Our reference: ECM 8375601
Contact: Gavin Cherry
Telephone: 4732 8125

12 October 2018

Notice of Exhibition – Nepean Hospital and Integrated Ambulatory Services Redevelopment (Stage 1) (SSD 8766) at 35 – 65 Derby Street, Kingswood

INTEGRATING CULTURAL LAYERS...

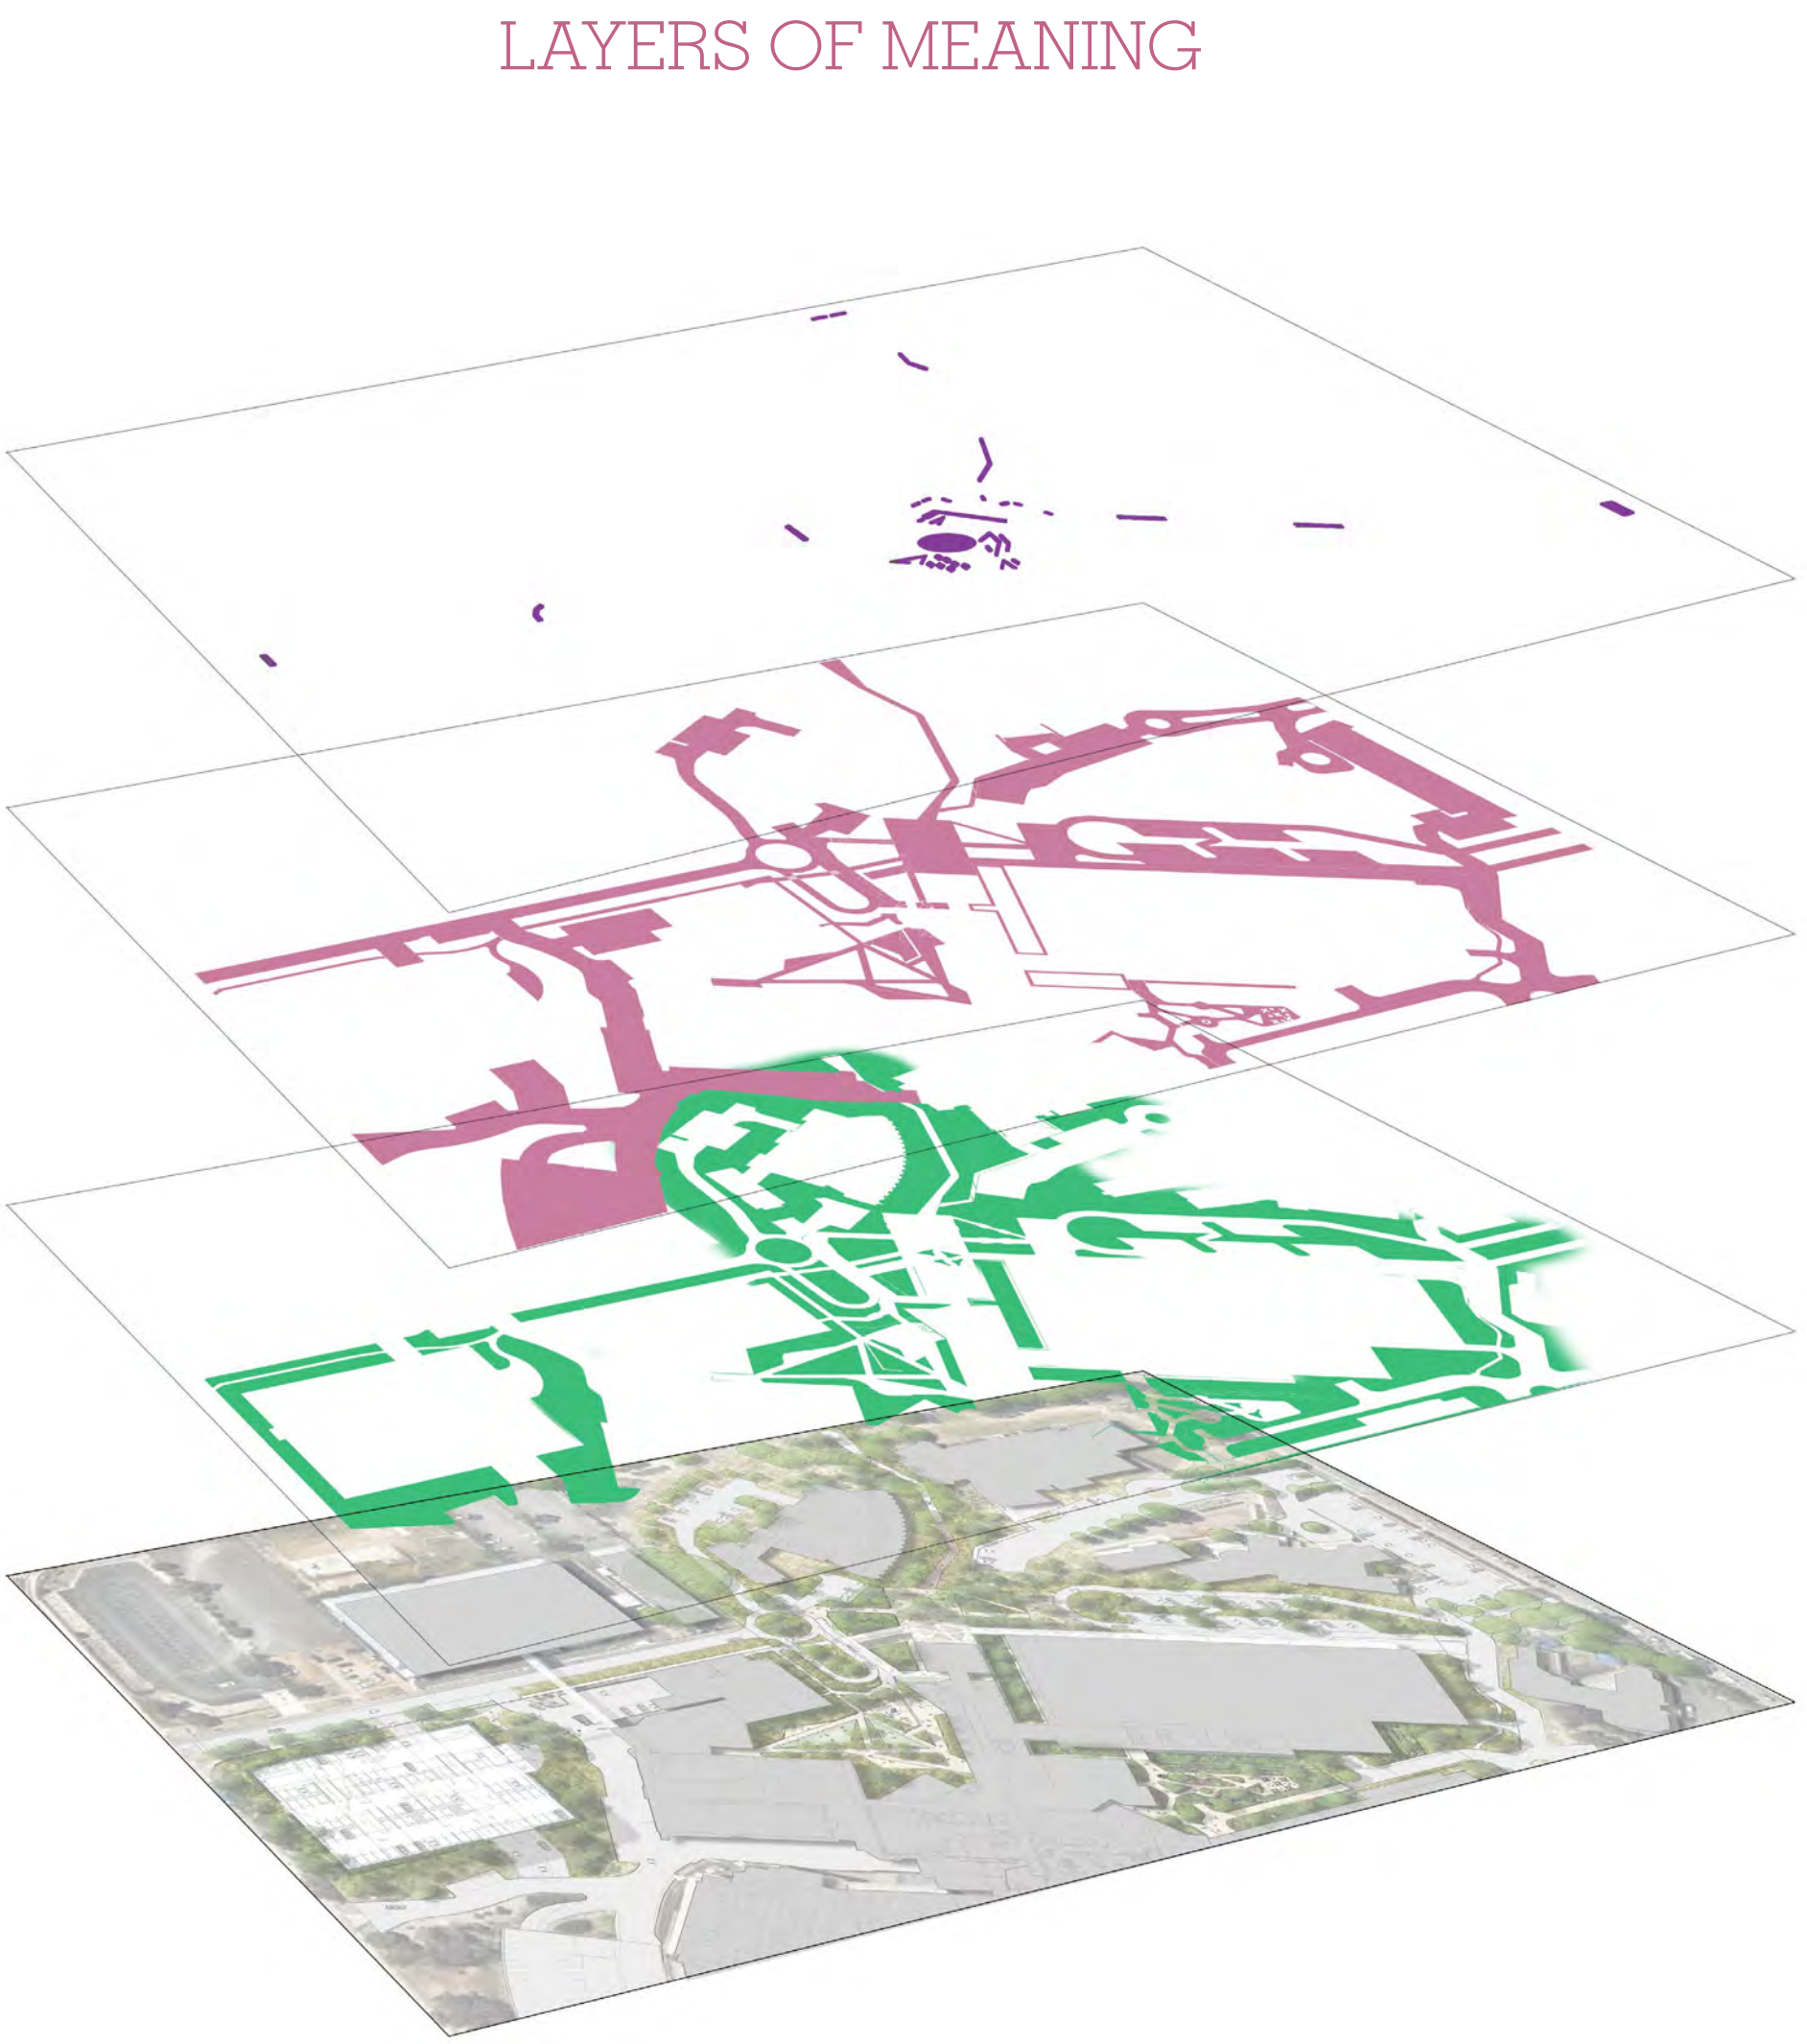
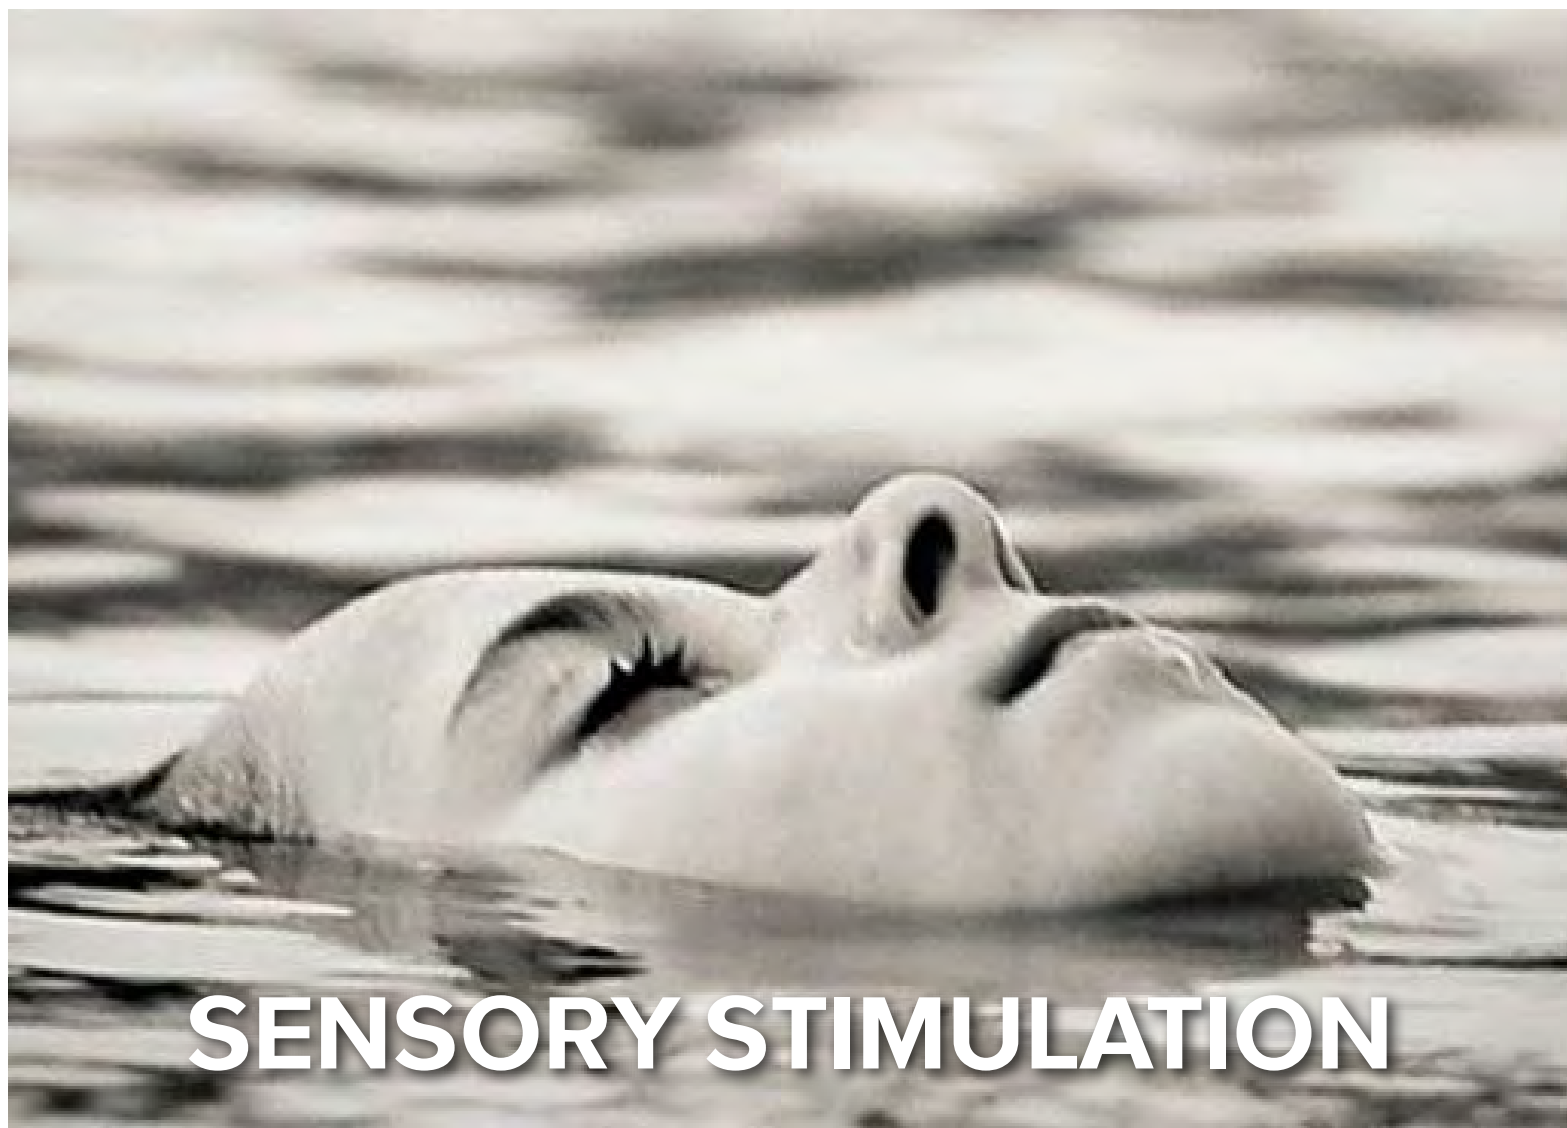
The proposed landscape vision for the site is predicated on a Blue Mountains character theme which is inappropriate given the availability of limited landscaped space and the urbanised nature of the development.

The site is not within the Blue Mountains and is located within a health and education precinct which will be surrounded by multi storey residential, commercial and medical developments rather than an expansive bushland setting.

The landscape theme and planting design should be revised to reflect the urban landscape setting in which the site sits, with suitable spatial separation between large canopy trees and plant species and densities suitable for this space.
